# Principal Areas of Disagreement Summary Statement (PADSS)

Version Number: **42**

This statement has been prepared by Horsham District Council (“the Council”) with input from the joint local authorities, technical consultants and legal specialists. The Northern Runway Project application was submitted to the Planning Inspectorate on 6 July 2023 and accepted for Examination on 3 August 2023. The Council is one of the local authorities identified by Section 43(2) of the Planning Act 2008 and in response to the Examining Authority’s (“ExA”) Procedural Decision letter of 8 September 2023 to the Applicant and the Host and Neighbouring Authorities, the Council has prepared this Principal Areas of Disagreement Summary Statement (“PADSS”) (Version 2). This Statement identifies the principal areas of disagreement and is considered to be a live document.

Diagram 3.3.1: Model performance before and after adjustment, Generic zone

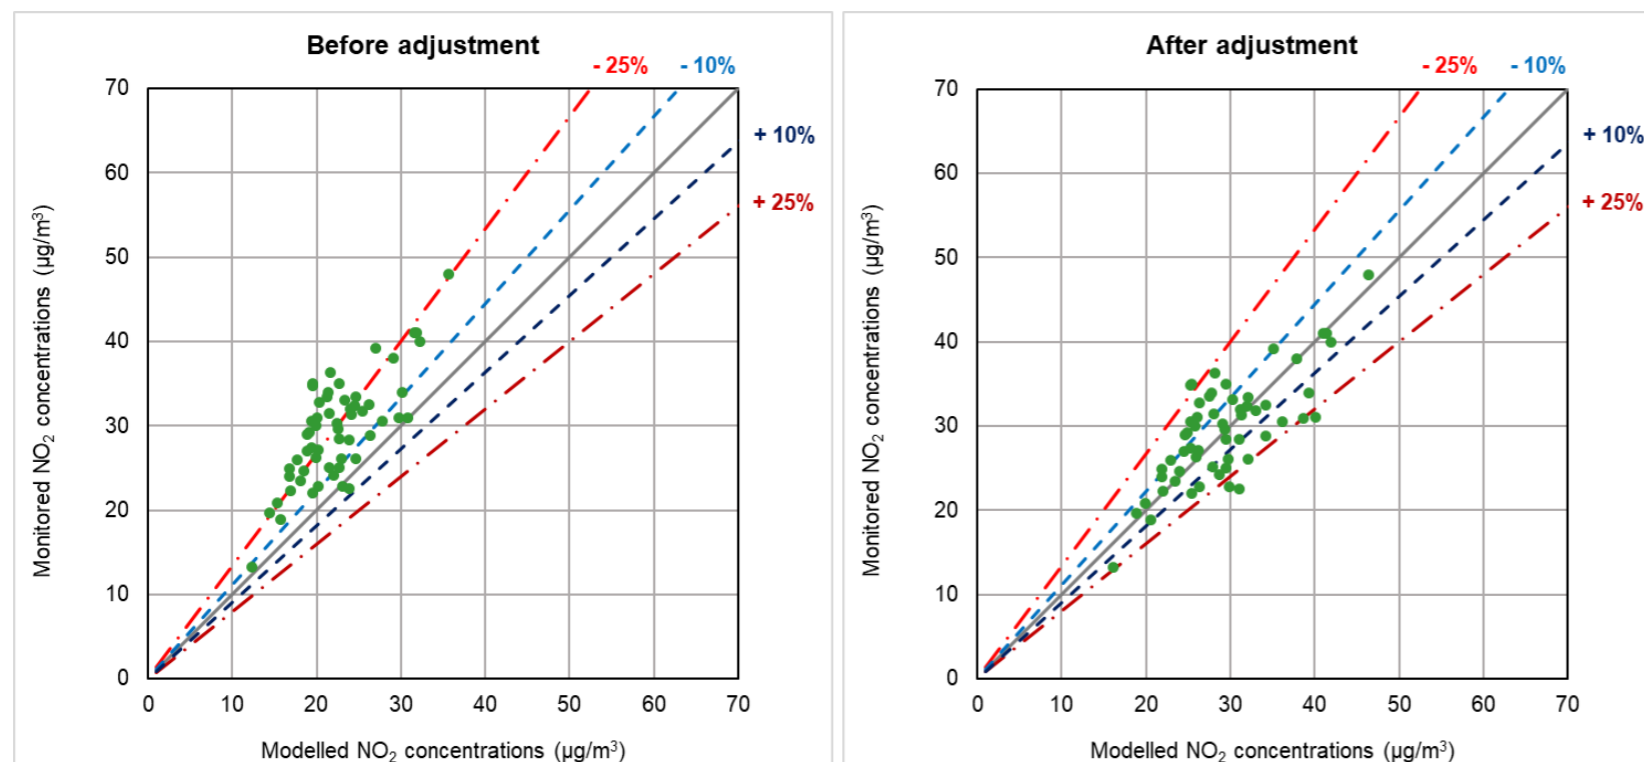
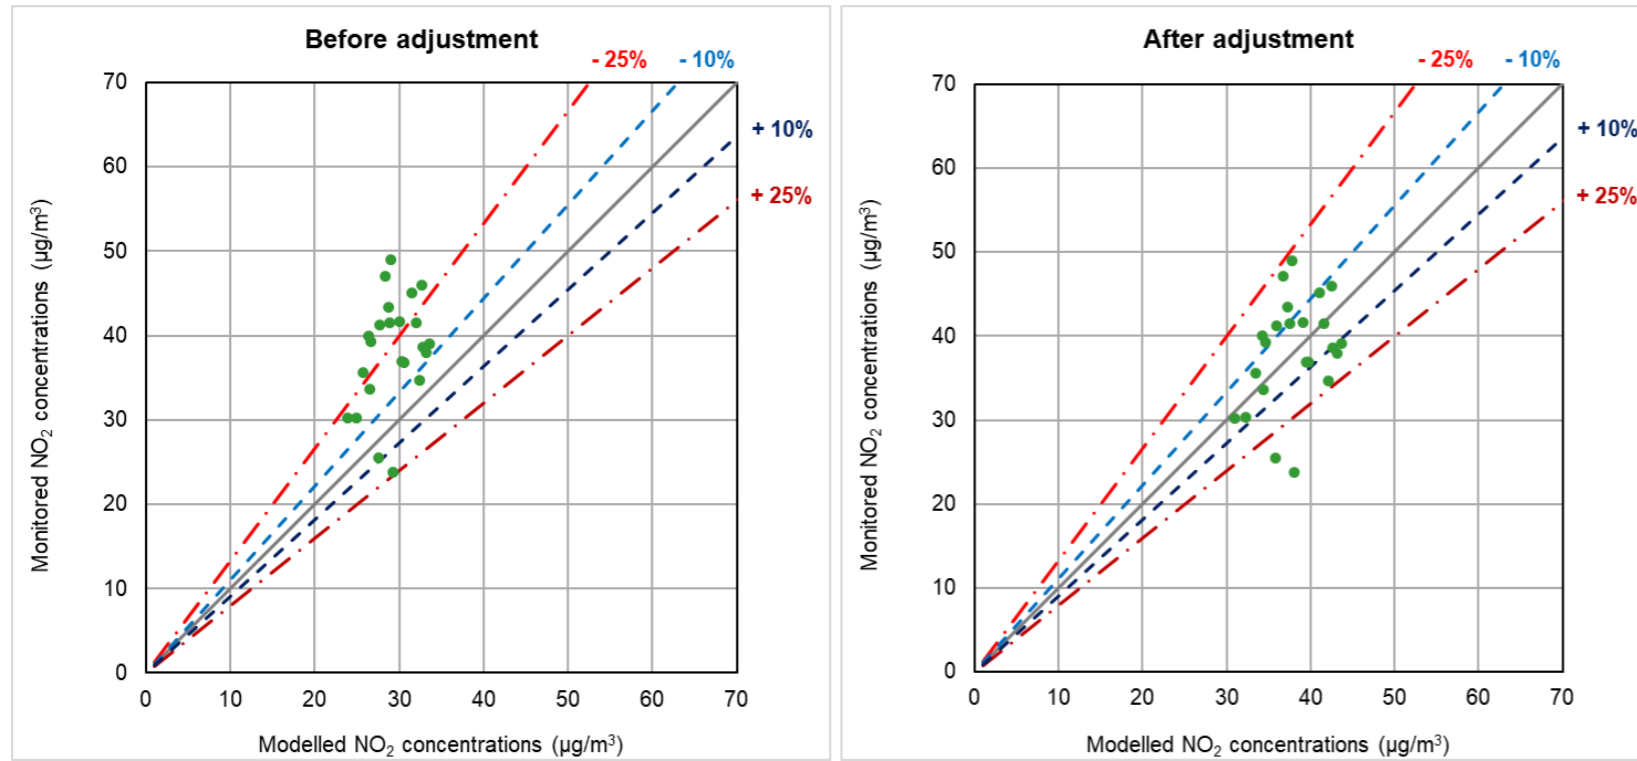
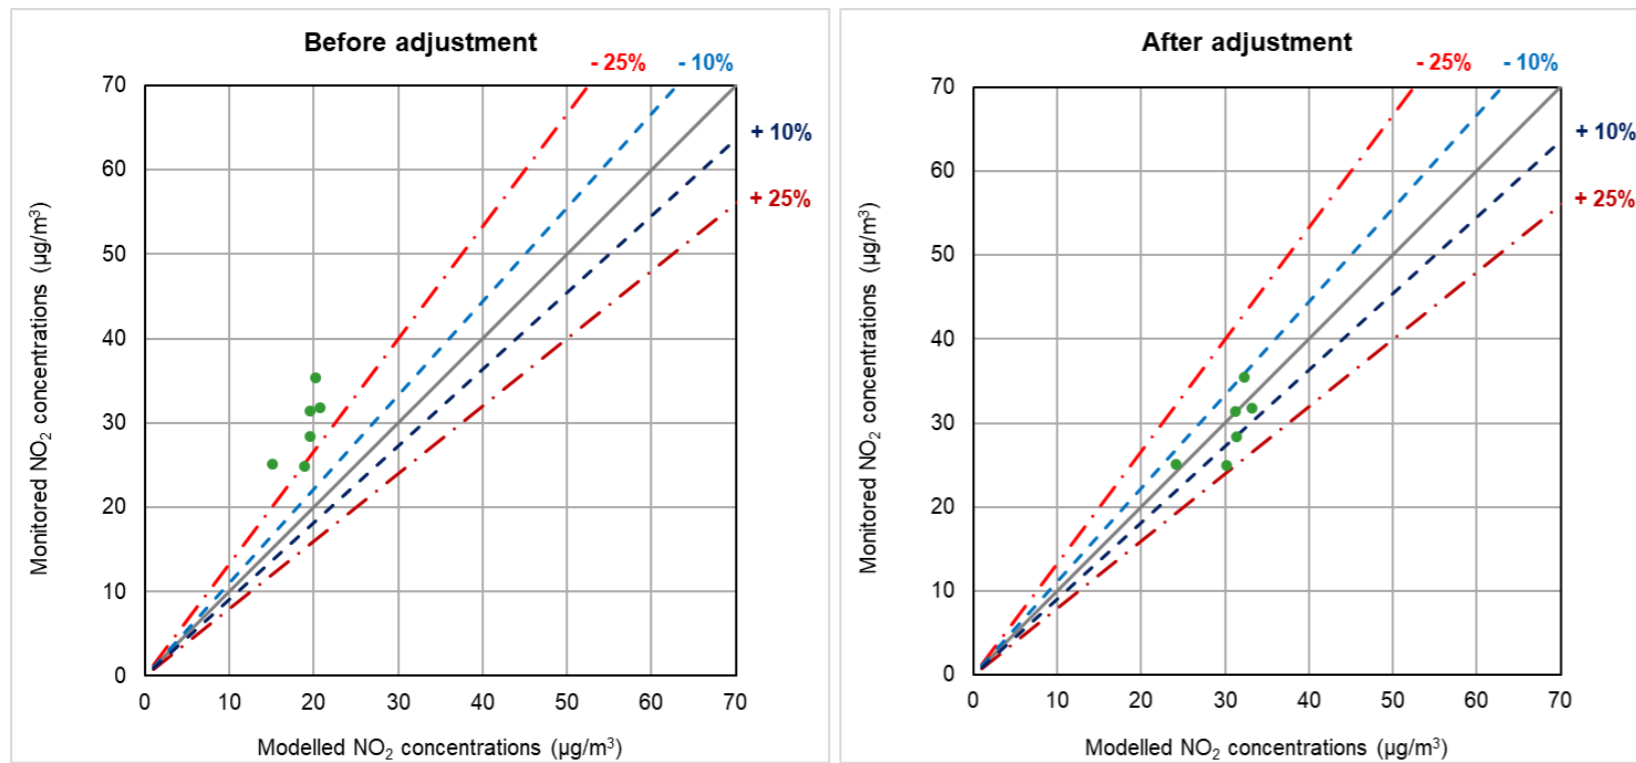
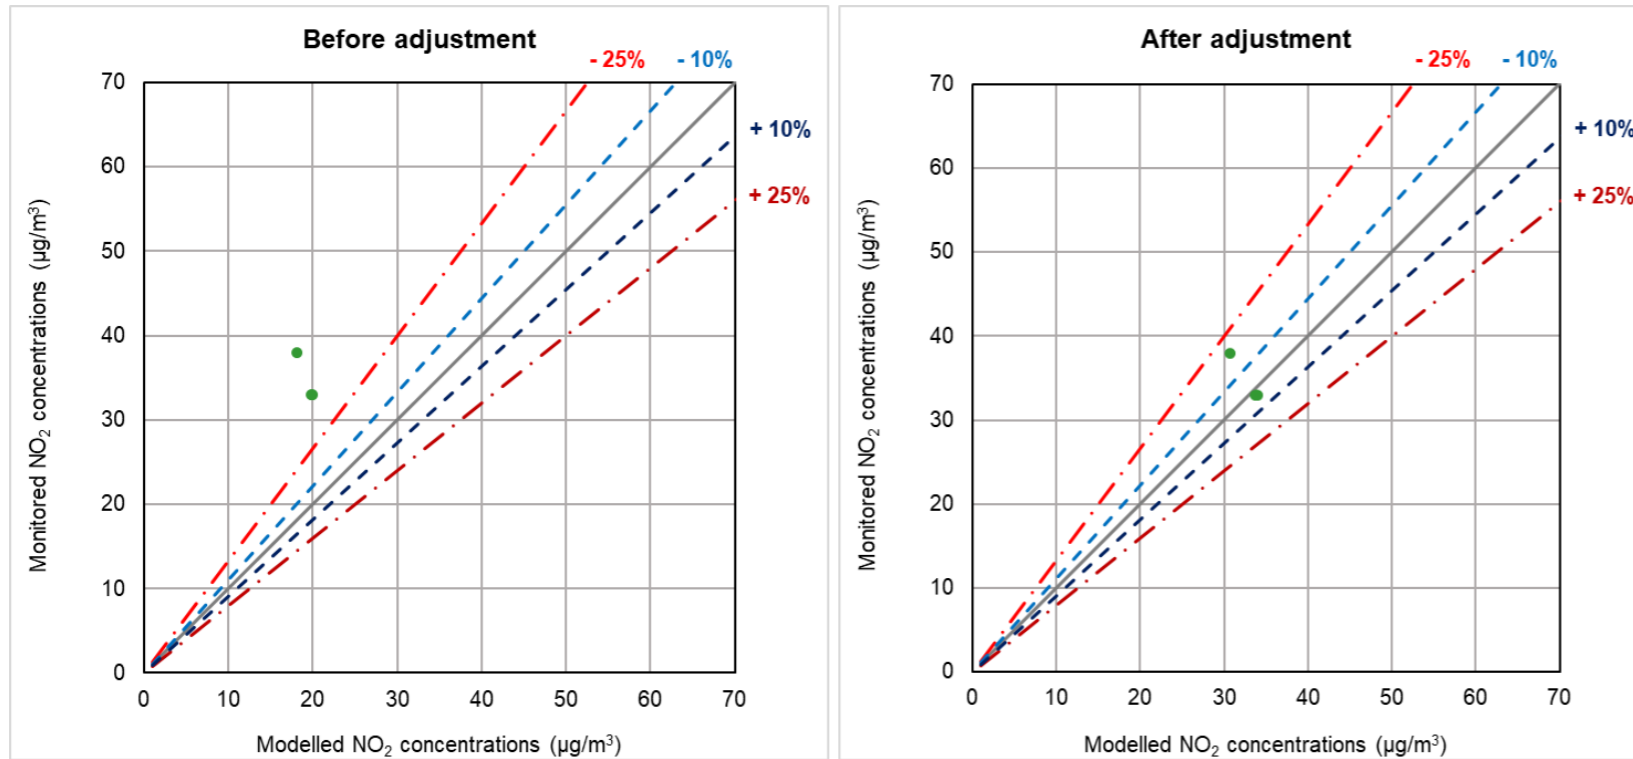
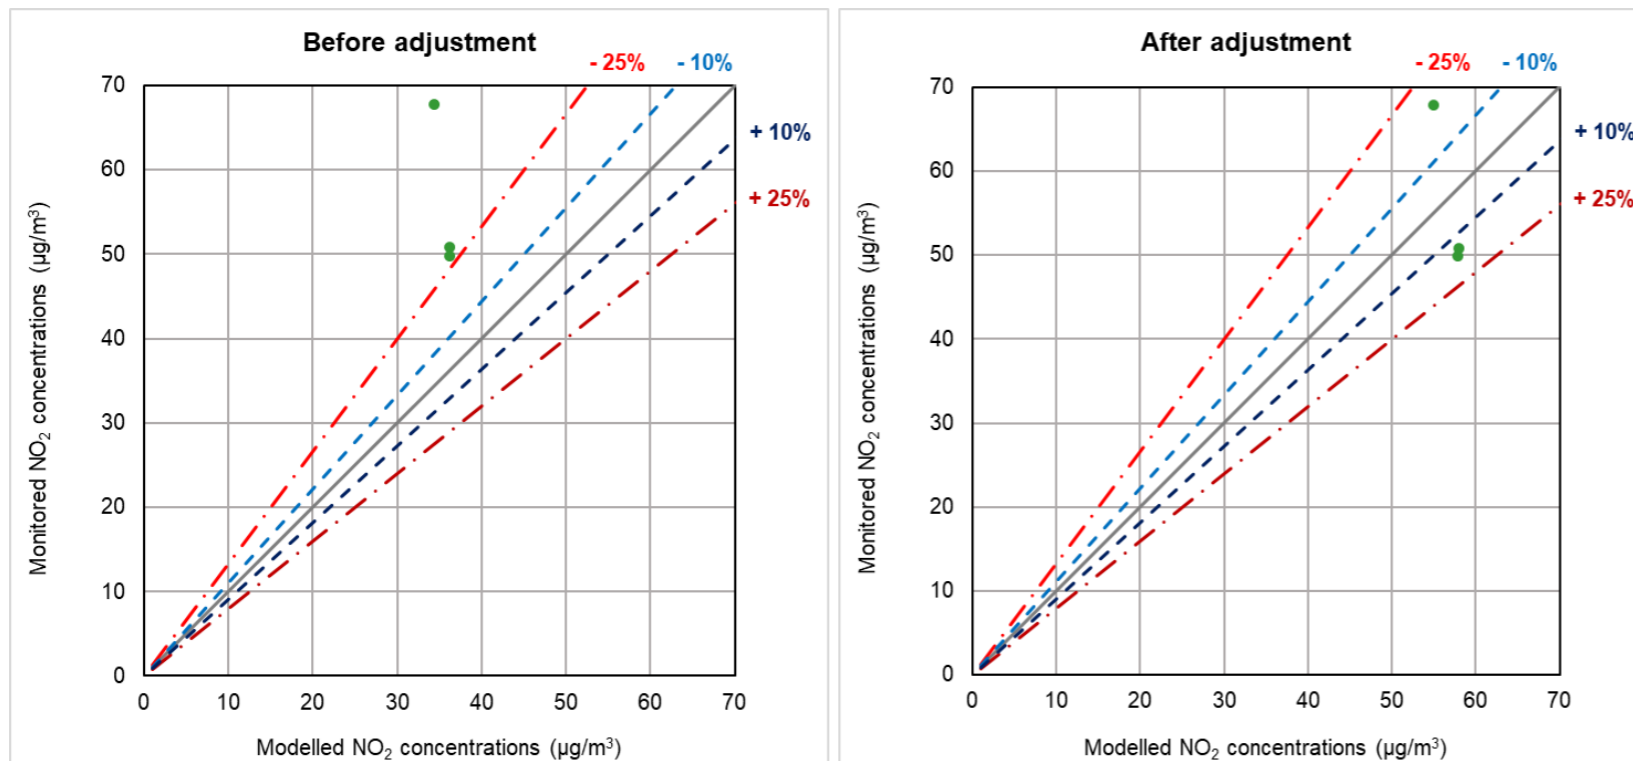
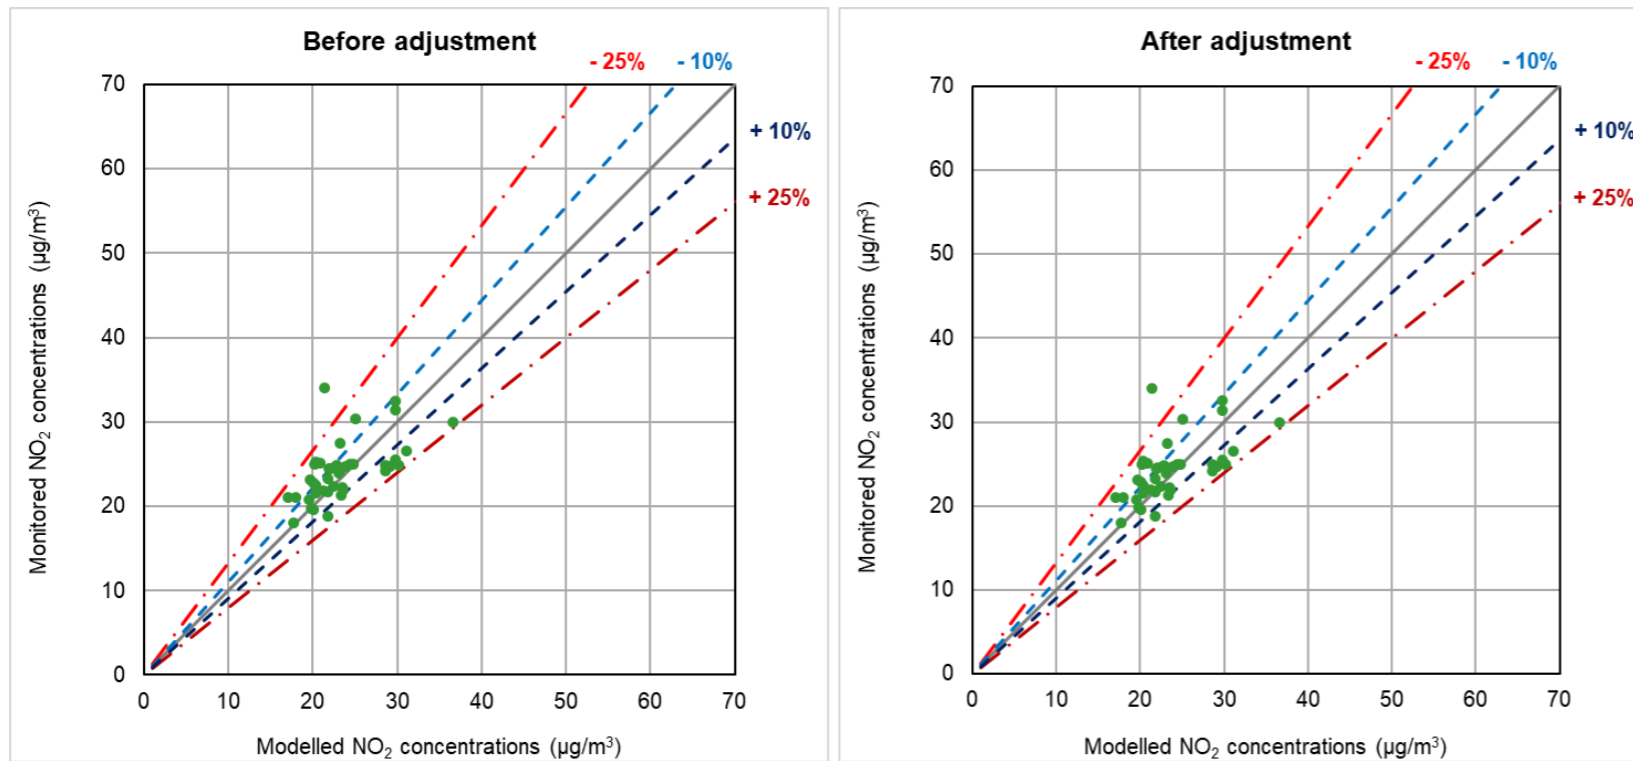
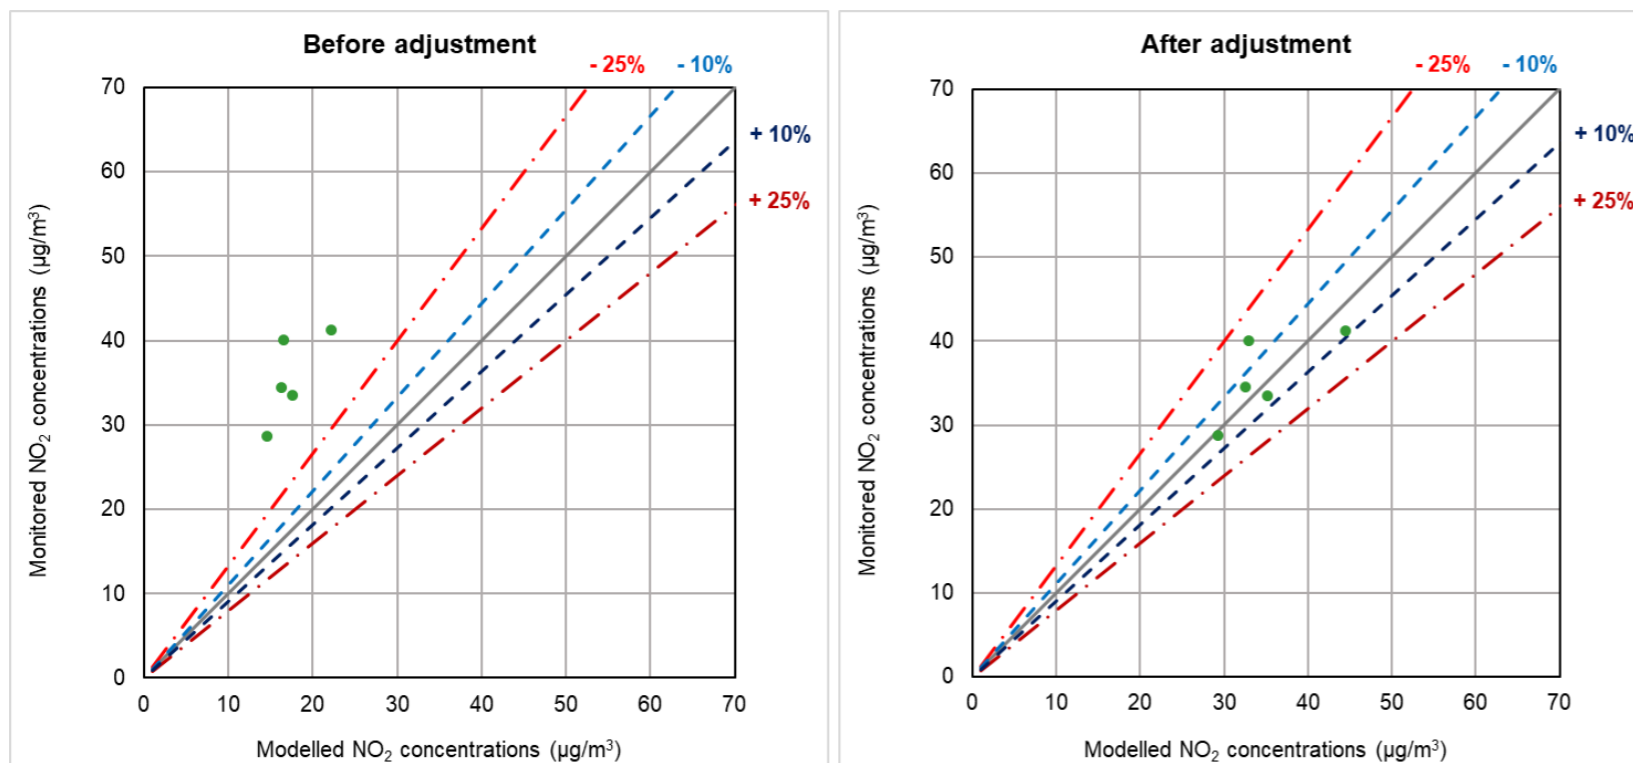
3.5	Model Set Up and Methodology	<p>Regarding model verification, Appendix 13.6.1: Air Quality Data and Model verification is missing details on how model verification factors for the selected zones were established. Details are required of the initial verification including Monitored Road NOx Contribution versus Unverified Modelled Road NOx, which monitoring sites were used, and which were removed from the verification process.</p> <p>To facilitate the scrutiny of the model set up and any assumptions used, it is requested that a complete set of input files be shared for 2018 (Base Year) and 2029 (nearest future year). In addition, Operational and Construction impacts for 2029 should be modelled jointly as one scenario, in order to enable the evaluation of all impacts associated with the development.</p>	The Applicant should provide further details in relation to the model verification	Uncertain
